Rezoning Transportation Analysis

Petition Number: #2022-157

From: Jake Carpenter, PE

Date	Description
02-22-23	First Review (TM)

REZONING SITE PLAN

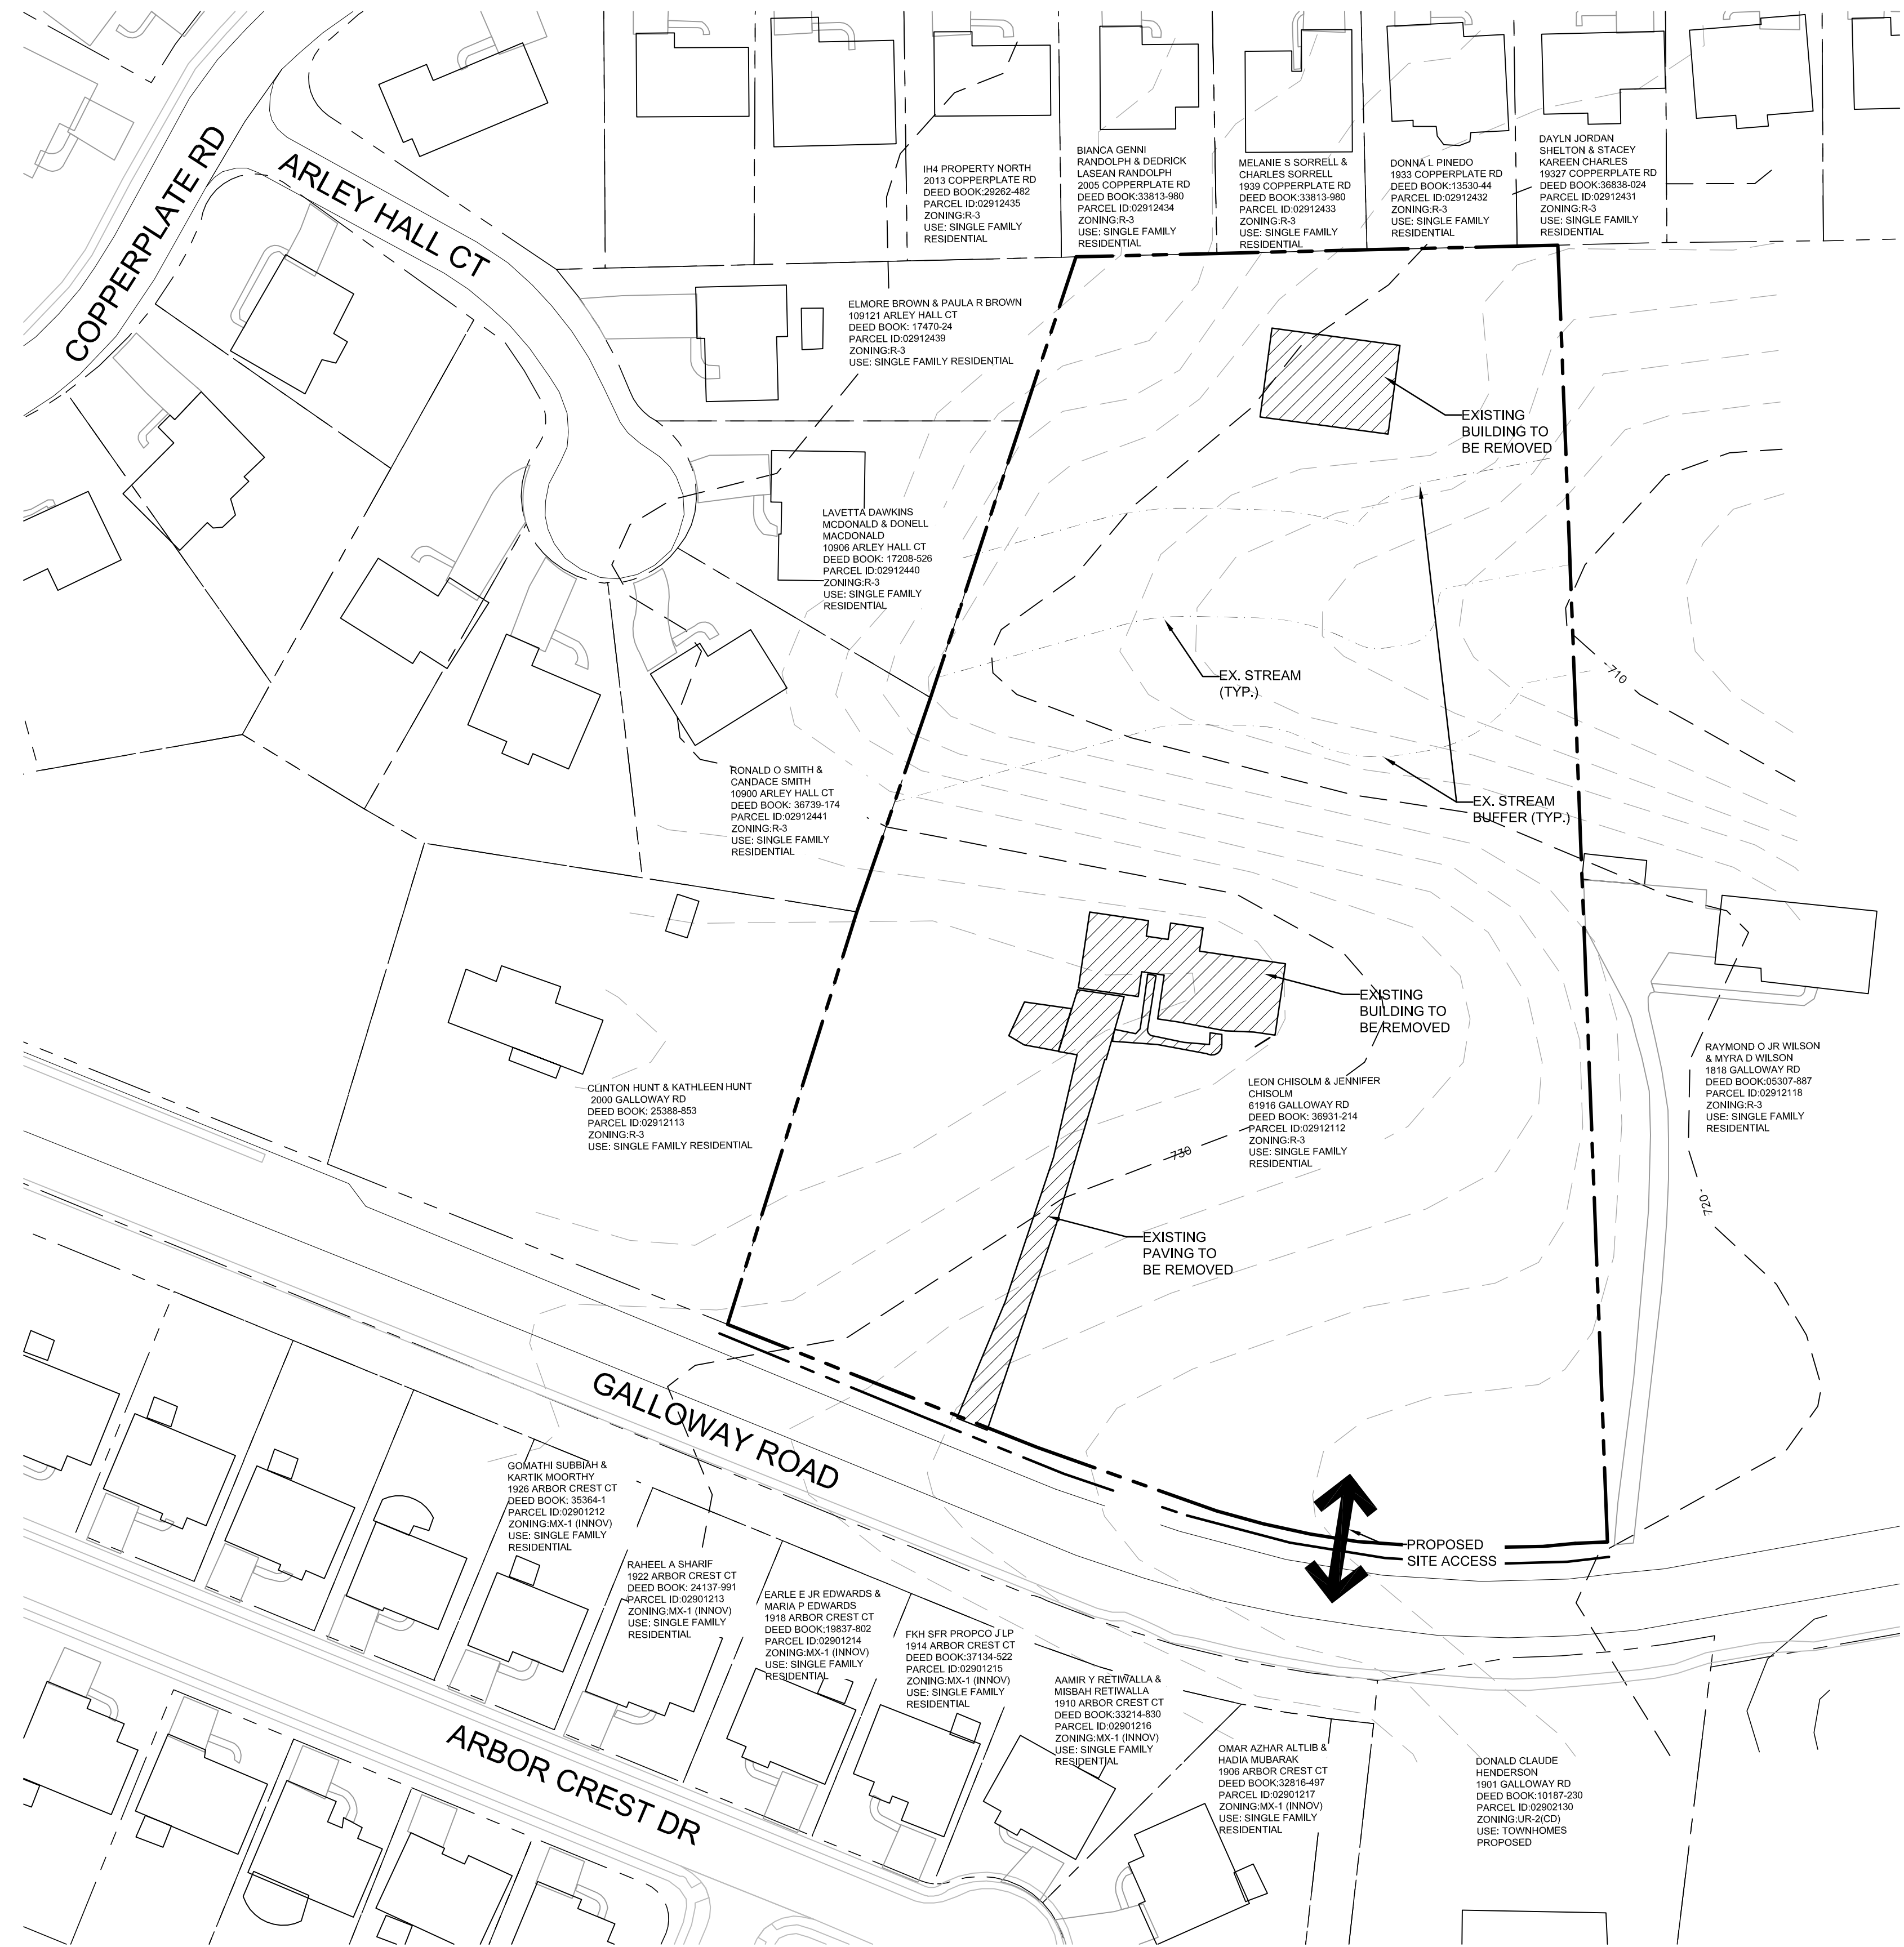
- a. **Galloway Road:** Location of curb and gutter to be moved to 17.5 feet from roadway centerline to accommodate the Charlotte Streets Map with a roadway typical per CLDSM U-07.

Label and dimension the curb and gutter from the centerline for each road on the site plan.

- 3. Revise site plan and conditional note(s) to commit to dedicate 36-ft right-of-way from the road centerline. The site plan shall label and dimension the right-of-way from the road centerline.
- 4. Revise site plan and conditional note(s) to commit to providing 75-feet of internal protected stem. Dimensioned from curb return to curb return.

6. CDOT REQUEST that site plan revisions and conditional note revisions are made to commit to constructing the internal private roadways and alleys to CLDSM standards 11.13 and 11.19 respectively. Site plan shall callout standards on site plan and noted in a conditional note.
7. Revise site plan and conditional note(s) to commit to extending private street stubs to the property line.
